D1 Submission: Design Concerns.

D1 Submission: More Concerns.

Illustrative Masterplan
Figure 5.3A: Cable Corridor Option A

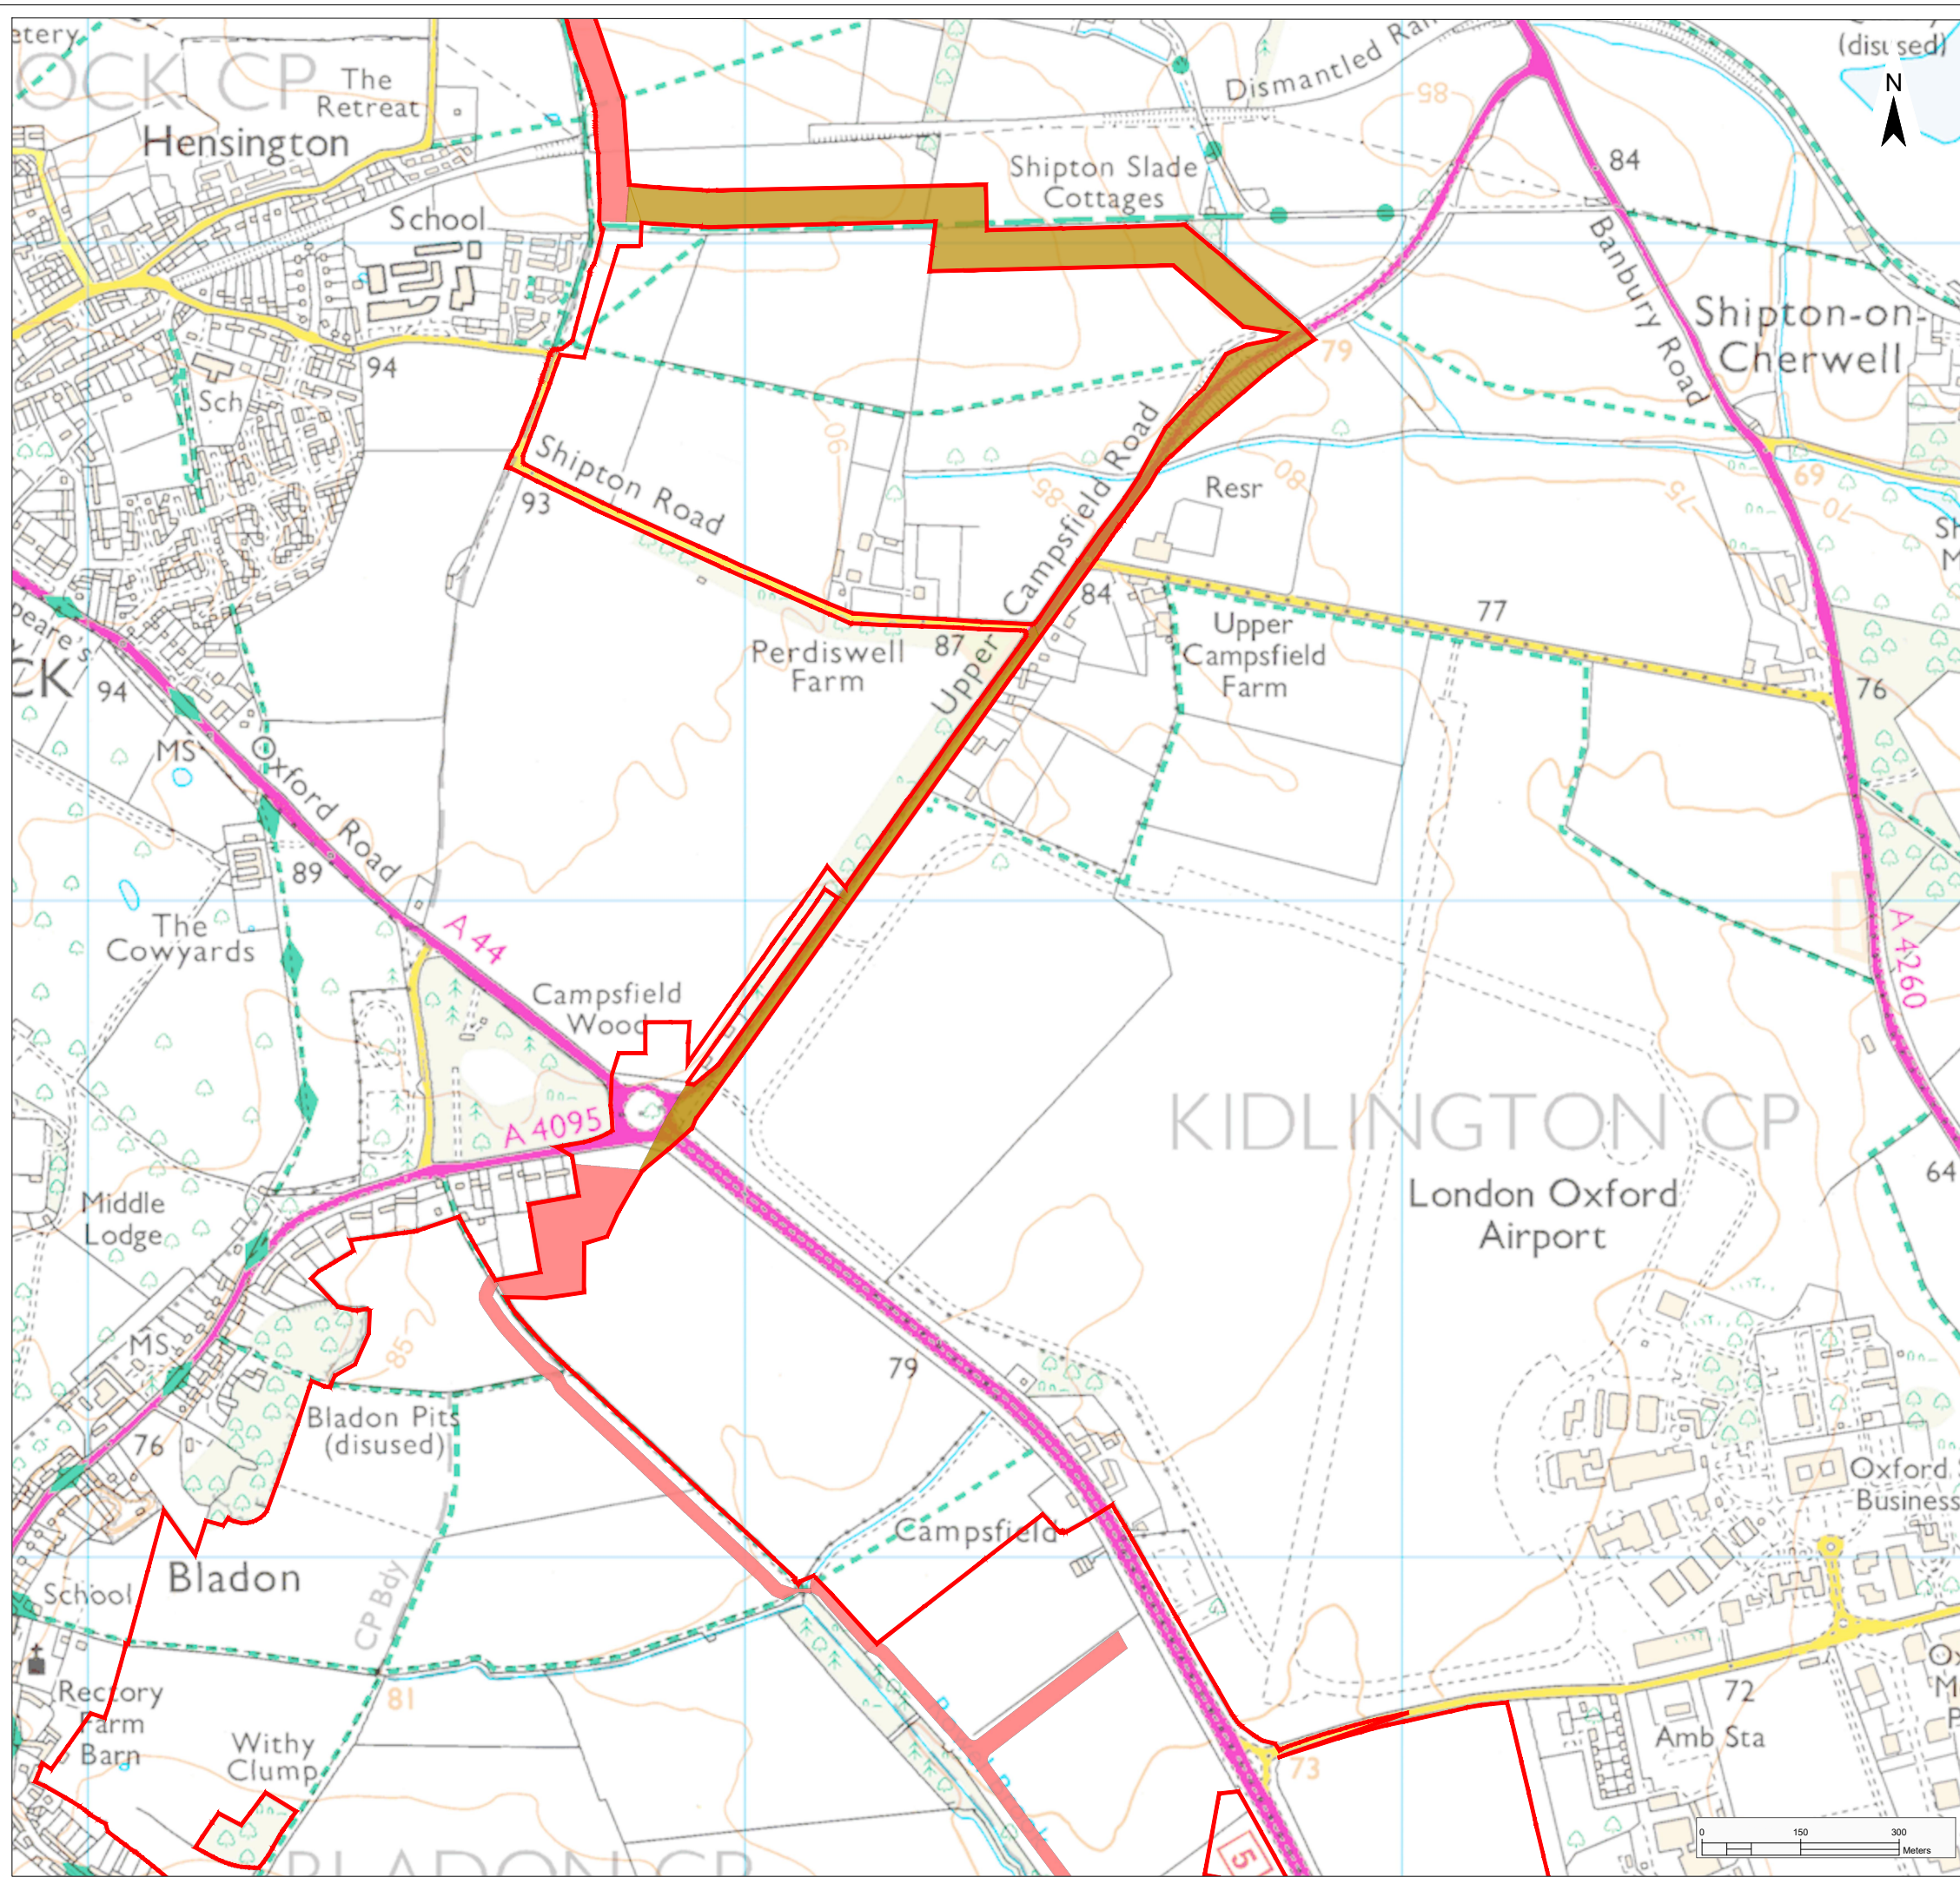
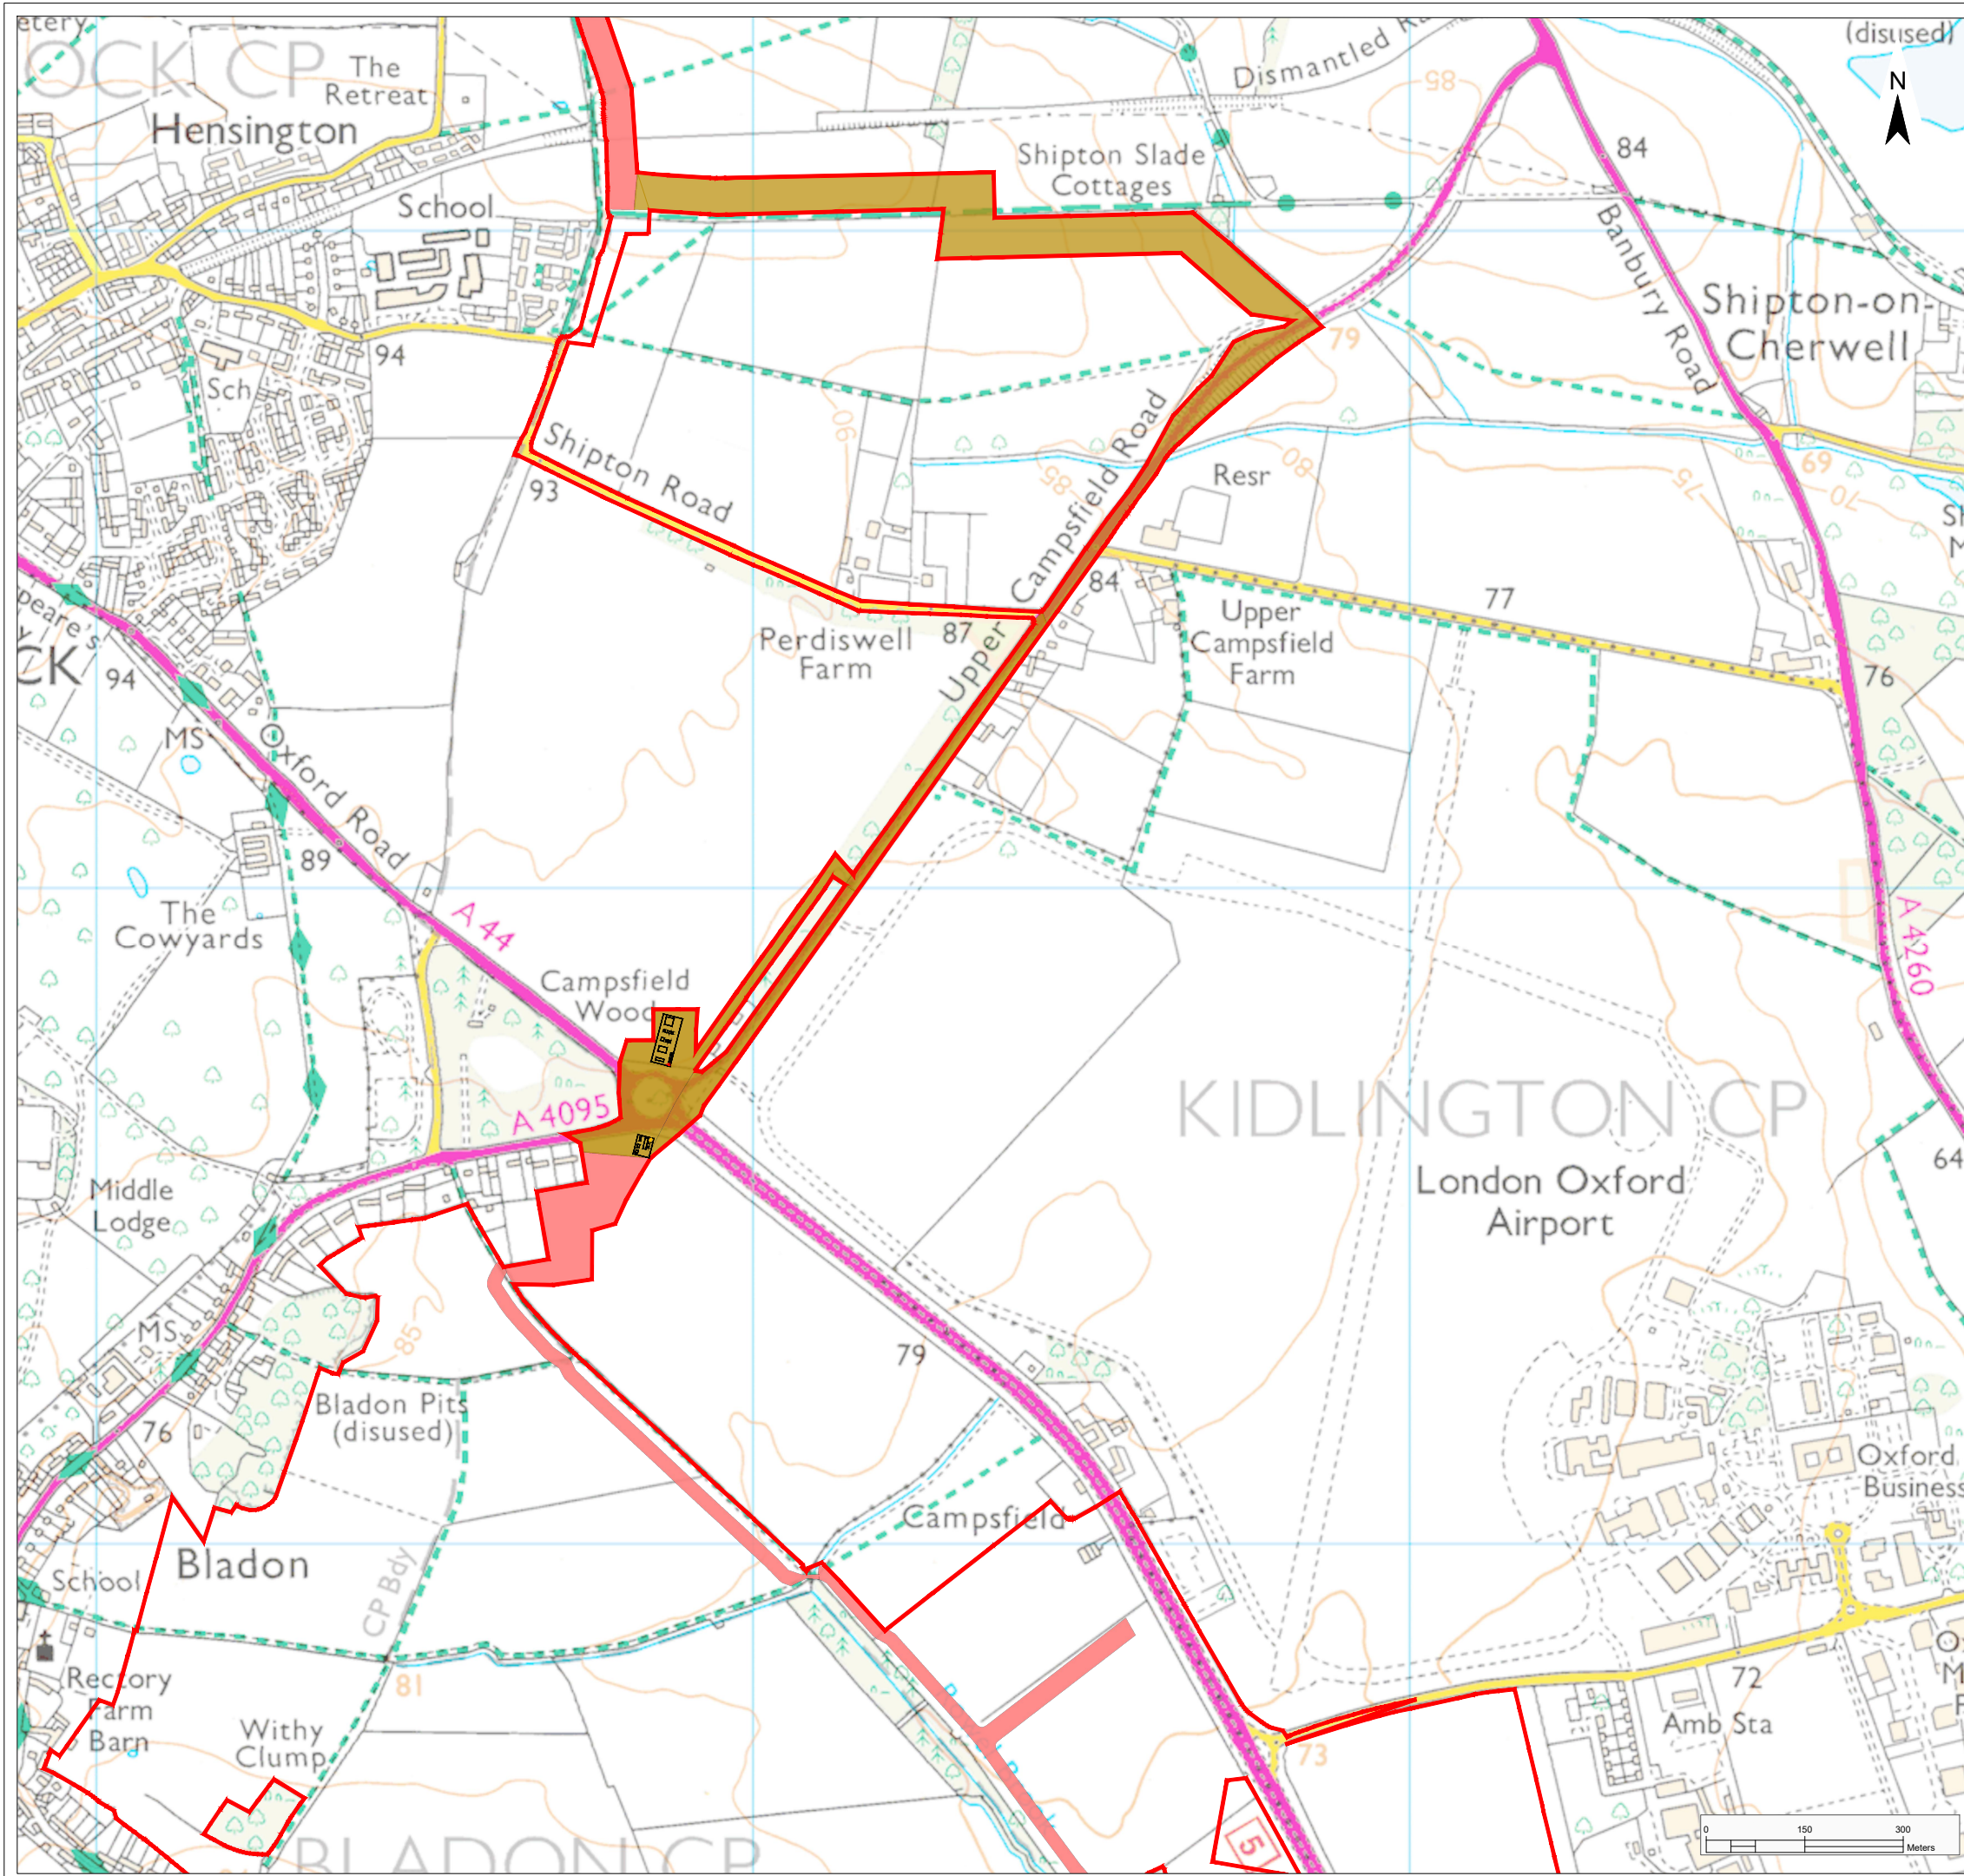
According to Table 6.3 of ES [Project Description](#) the scheme will have between 1,800,000 and 2,200,000 PV panels. This is somewhat lower than the range previously anticipated in the [Scoping Report](#) (Table 6.1) at 2,500,000 to 2,800,000. As a provisional [Illustrative Masterplan](#) has now been drawn up, what is the Masterplan panel count?

Zooming in on the Masterplan confirms that a 'standard' table comprises 26 PV panels in portrait configuration (13×2) as described in the Scoping Report. (Project Description omits the standard table.) This is consistent with the dimensions of the Longi LR5-72HGD panel ($2278 \times 1134\text{mm}$) specified in Table 14.7 of ES [Climate Change](#).

1) There are many ultra-short tables (e.g. **1** and **2** in the diagram). The Scoping Report gave a minimum table length of 14m. Project Description reduced this to 3m. Table **1** looks like a single panel width: 1m.

A brief survey on Google Satellite suggests that no tables on UK farms are less than 8m. Are these ultra-short tables drawn in error, or is PVDP pushing the envelope on table design?

2) The Masterplan also shows the network of roads (**R**) than run around the perimeters and across the fields. These are coloured grey here but are described as 'grass with occasional matting' or 'natural ground surface' [[OOMP](#), p6]. Are these sufficient to support the weight of emergency fire tenders year-round? Has Oxfordshire Fire and Rescue been consulted? The roads look a bit narrow for the job (2.5m), and the turn radii are certainly far too tight to be negotiated by a fire tender. Should some panels be removed to relax the radii?

How will a replacement PCS be delivered to its location? These are the size of a standard trailer unit [[Project Description](#), Table 6.3]. An articulated lorry plus crane would be unable to reach their destination on BWSF's internal roadways.

3) The north-south table gap is specified in Project Description as between 1.5m and 3.0m; the gaps measured on the Masterplan are 1.5m (panel:gap ratio 3:1).

This is considerably narrower than the 4.0m gap that one sees typically in the UK. At lower latitudes tight spacing might be acceptable, but up here at 52°N the sun never gets very high: tight spacing will result in excessive energy loss for much of the day due to self-shading (shadow from the adjacent row of panels to the south).

4) Similarly, Table 6.3 of Project Description specifies a minimum distance of 7m between the fencing and the solar tables, whereas the Illustrative Masterplan shows PV panels consistently packed in with a fence separation of less than 5m.

Is this an interim layout subject to revision upon further critical review?

An appealing feature on the [Illustrative Masterplan](#) is the inclusion of Skylark Plots, shown as brown squares, within the solar arrays. These are described in section 11.6 of [Outline Landscape and Ecology](#), and broadly follow the guidance in the government's set-aside compensation scheme [AB4: Skylark Plots](#). ("Unsown plot" in 11.6.3 presumably means an area not 'sown' with solar panels.)

The Landscape language is similar to that of AB4, with the exception that PVDP calls these 'foraging areas' rather than the nesting sites intended by AB4. The 50m rule is not observed in the Masterplan drawings.
